**Response to Department of Planning and Environment Request for
Further Information for SSD 6746 MOD 1 – UTS Blackfriars Precinct
Research Building**

SSD 6746 MOD 1 - UTS Blackfriars Precinct Research Building
Schedule 1: Requested Information

Drawing Title
UTS BLACKFRIARS CAMPUS CB23
**A17 - DETAILED SHADOW
ANALYSIS - 2**

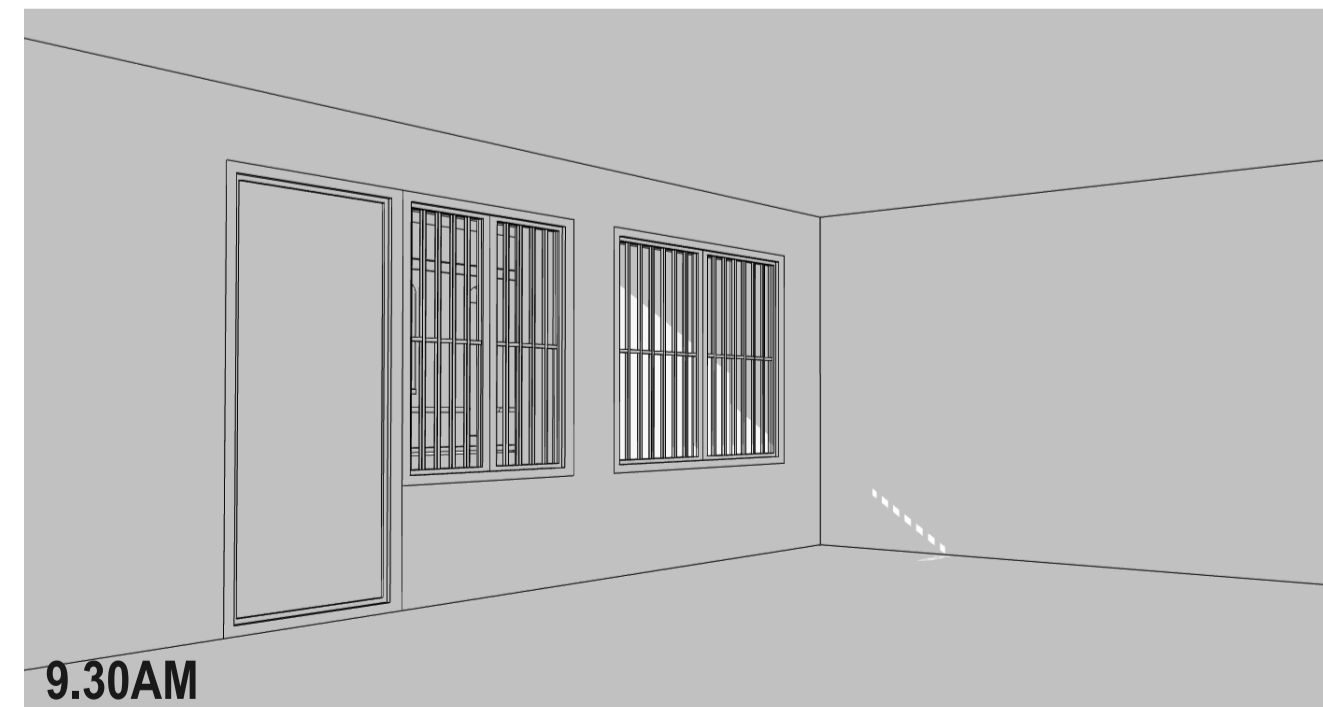
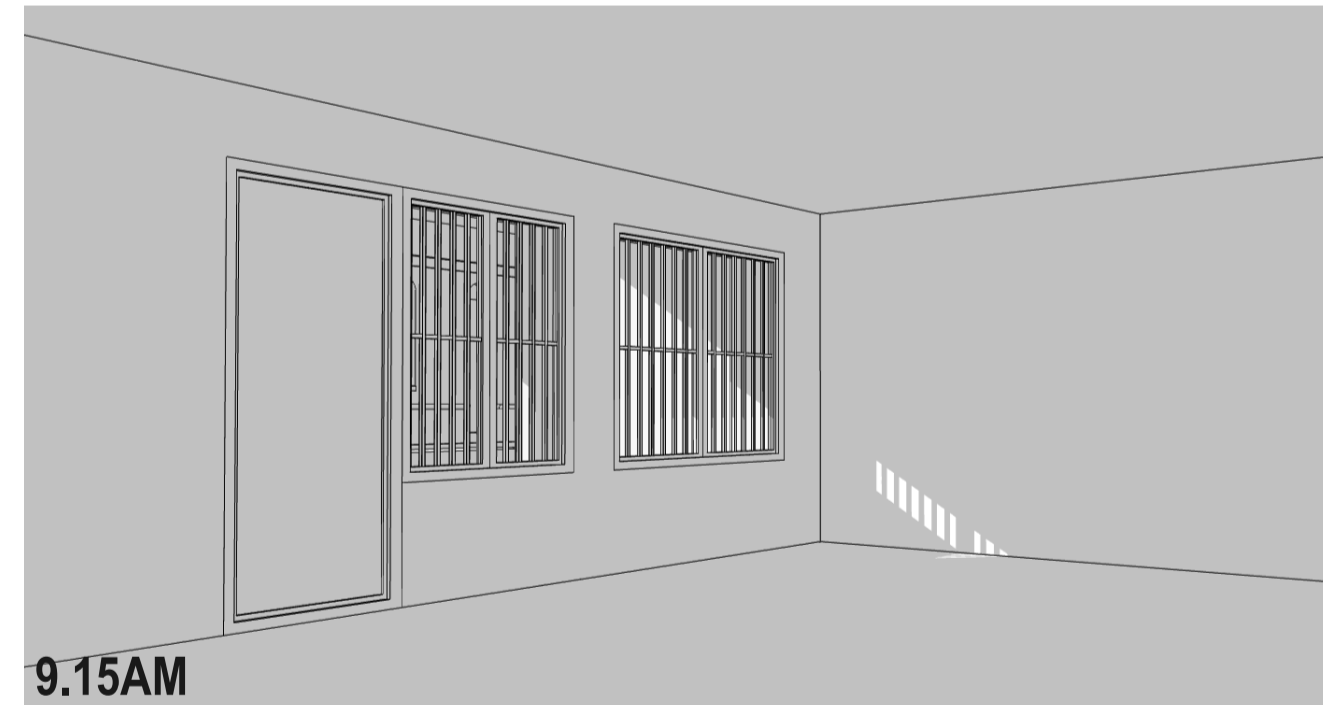
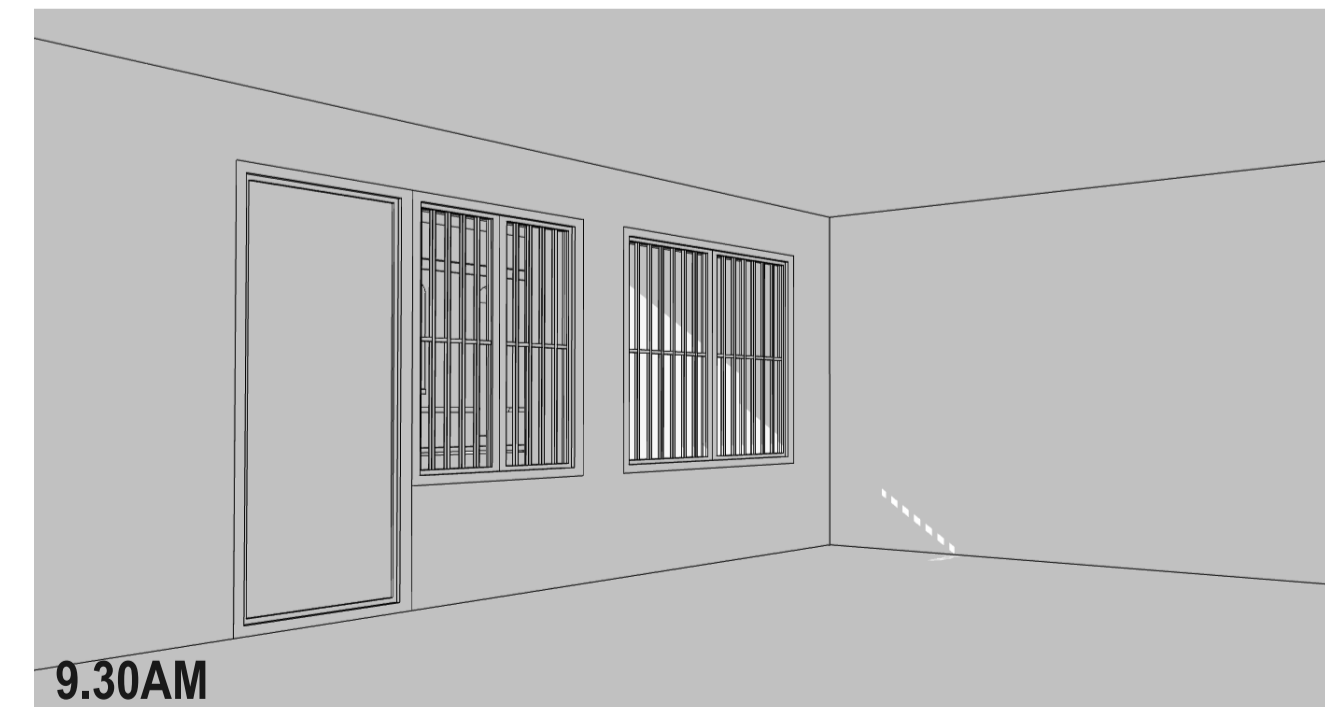
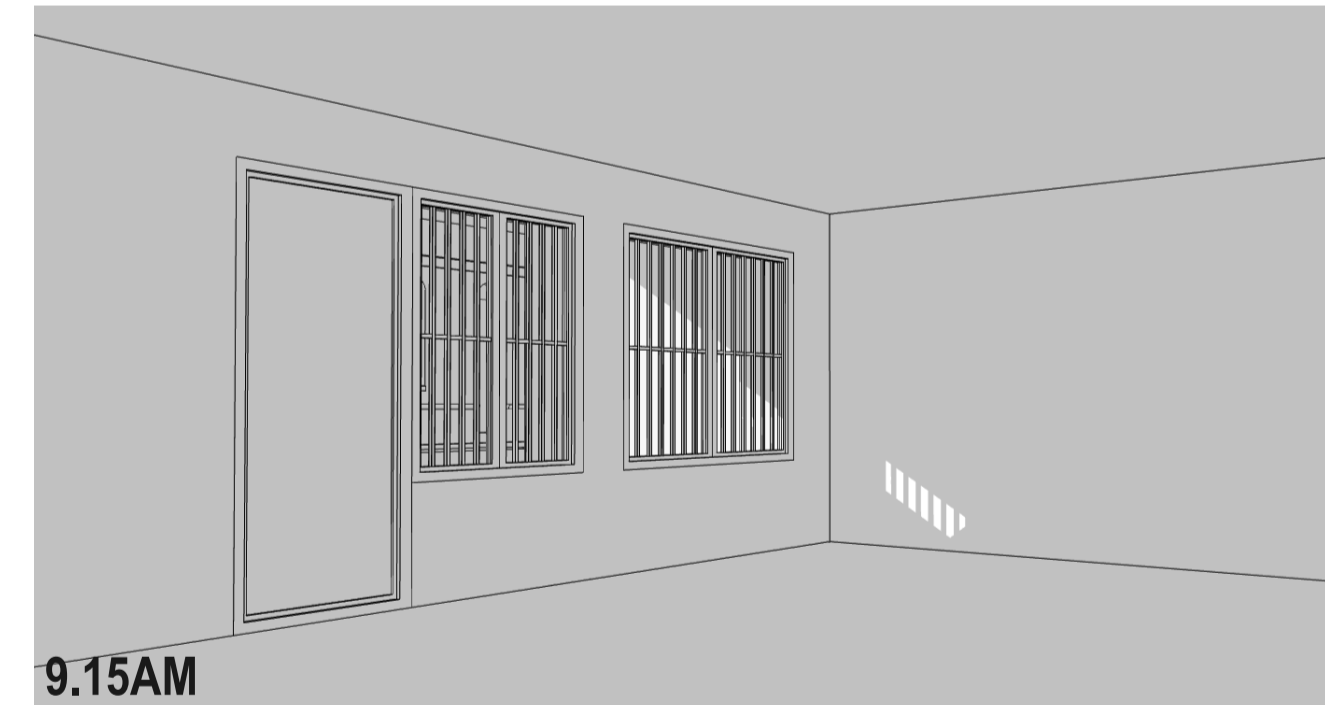
Requested Information	Where the information is located, and relevant comments
<p>14. Provide views of the skyline from Abercrombie Street and Broadway, showing the additional height proposed to the building envelope in relation to the St Benedict's Church.</p>	<p>3D views from Abercrombie St and Broadway are provided in Drawings A23 and A24 in Attachment A4</p>
<p>Shadow diagrams</p>	
<p>15. Provide elevational shadow diagrams identifying the existing, approved concept plan and proposed modification, solar access to 23 Buckland Street/ 2 Grafton Street.</p>	<p>An elevational shadow diagram is provided at drawing A18 - ELEVATIONAL SHADOW ANALYSIS.</p> <p>A second drawing A18 shows the shadows from the design competition winning building that will be the subject of the Stage 2 application, provided for information only.</p>
<p>16. Provide an internal floor plan for unit 29/23 Buckland Street.</p>	<p>An internal floor plan sourced from the City of Sydney Archives [DA Plan - Scanned Plans - BUCKLAND STREET 23 - 55 CHIPPENDALE - 14515 - U97 00306 - ERECT 107 RESIDENTIAL APARTMENTS WITH CAR PARKING - \$9000000 - MENDIRO PTY LTD - 14 04 97.PDF] is provided at Attachment C. The relevant apartment has been coloured on the attachment.</p>

APPROVED ENVELOPE - PLAN

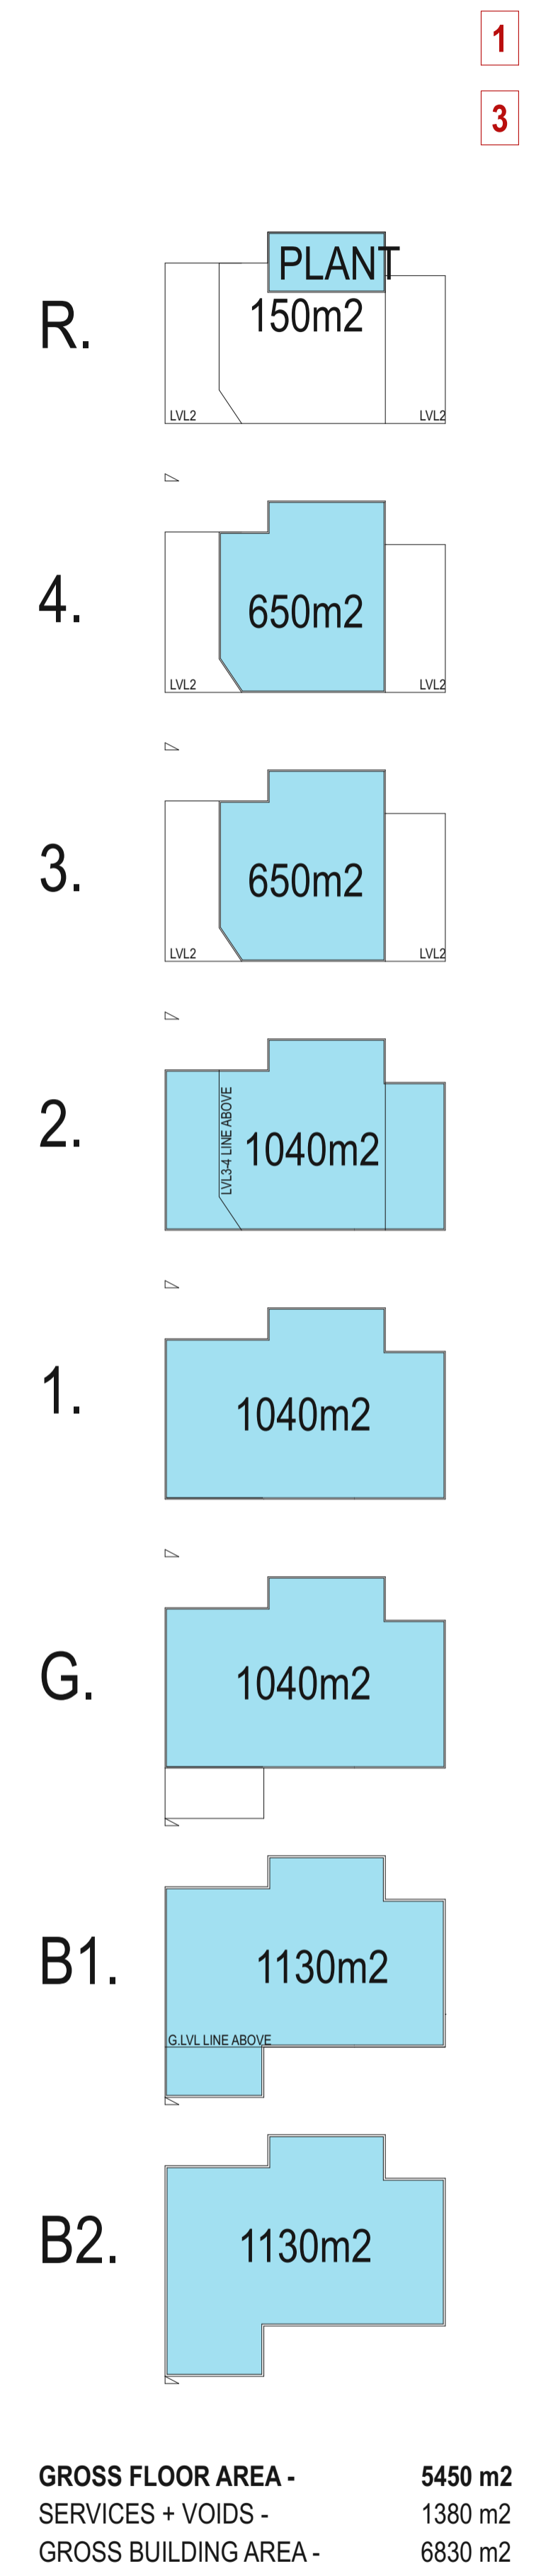
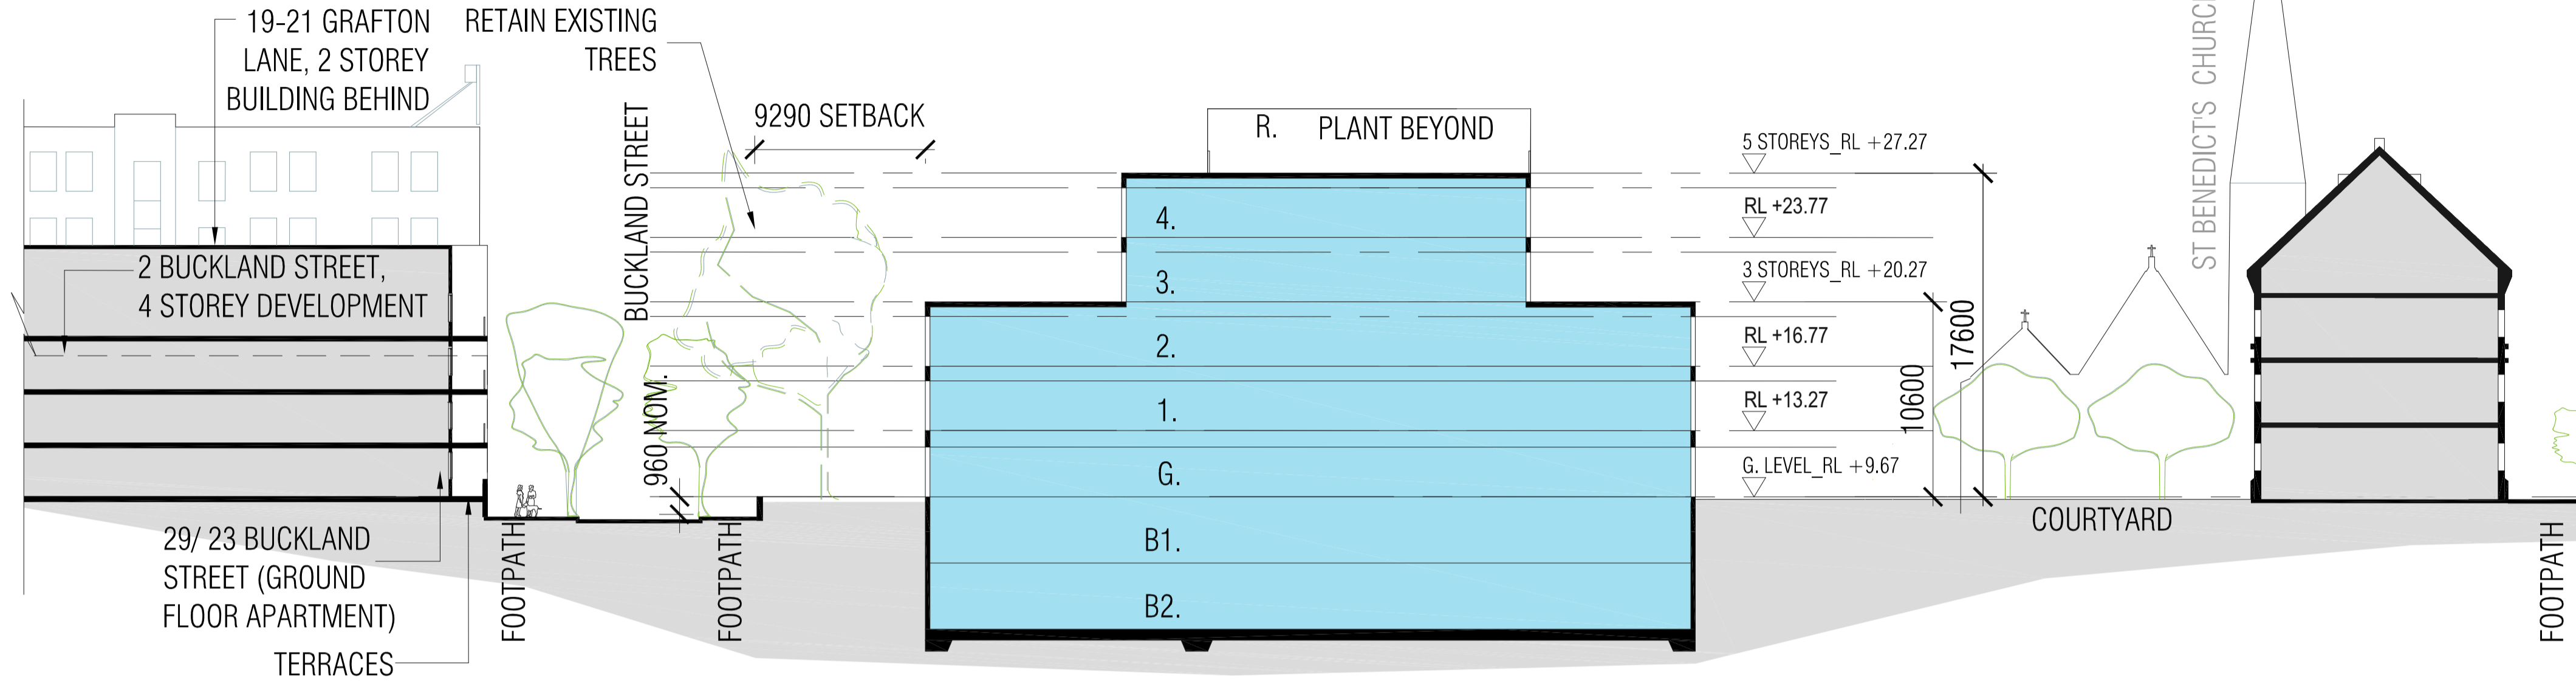
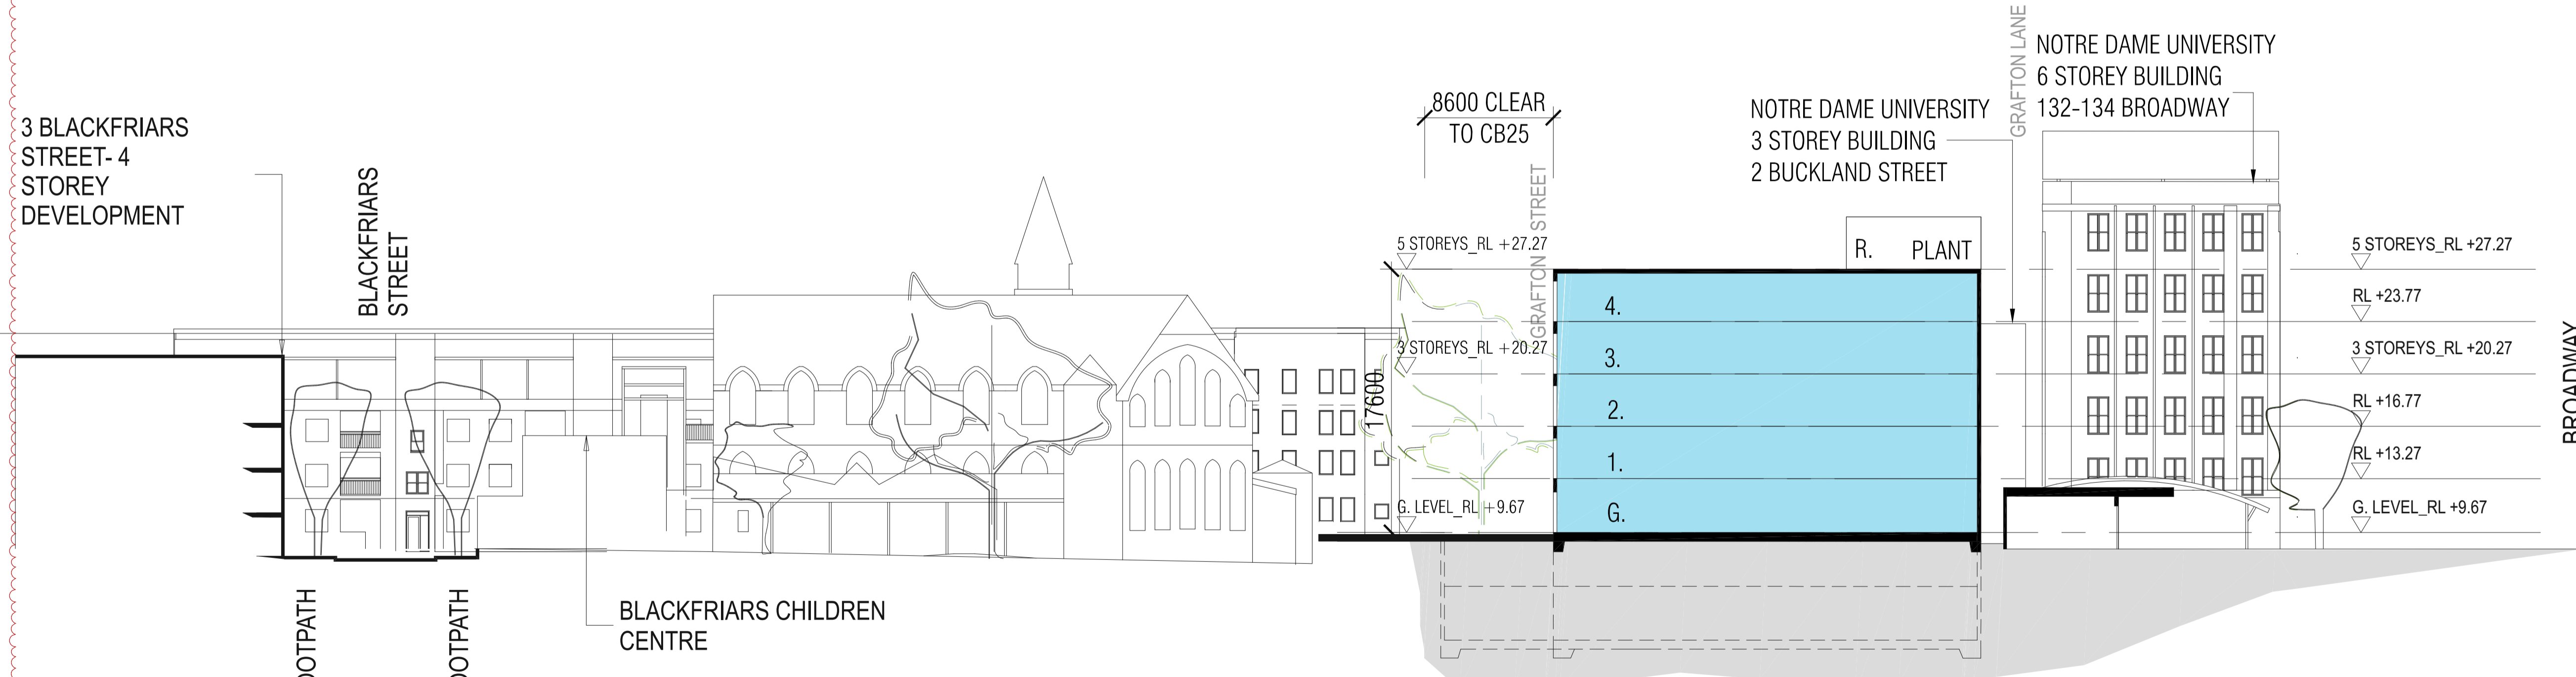
<p>2. Show the proposed RL's on the building envelope plan. The RL is to identify the maximum proposed height of the eastern side of the building (i.e. include provision for any future balustrade).</p>	<p>The proposed maximum RL of the envelope at the eastern side of the building is shown on drawing A02 - PROPOSED BUILDING ENVELOPE PLAN and on drawing A03 - PROPOSED BUILDING ENVELOPE SECTIONS and is RL22.430</p>
<p>3. Identify the gross building area and gross floor area that can be achieved in the envelope as approved by the conditions of consent.</p>	<p>The Gross Building Area and Gross floor Area are identified on drawing A01-1-APPROVED ENVELOPE PLAN and are estimated at 6830m² and 5450m² respectively</p>
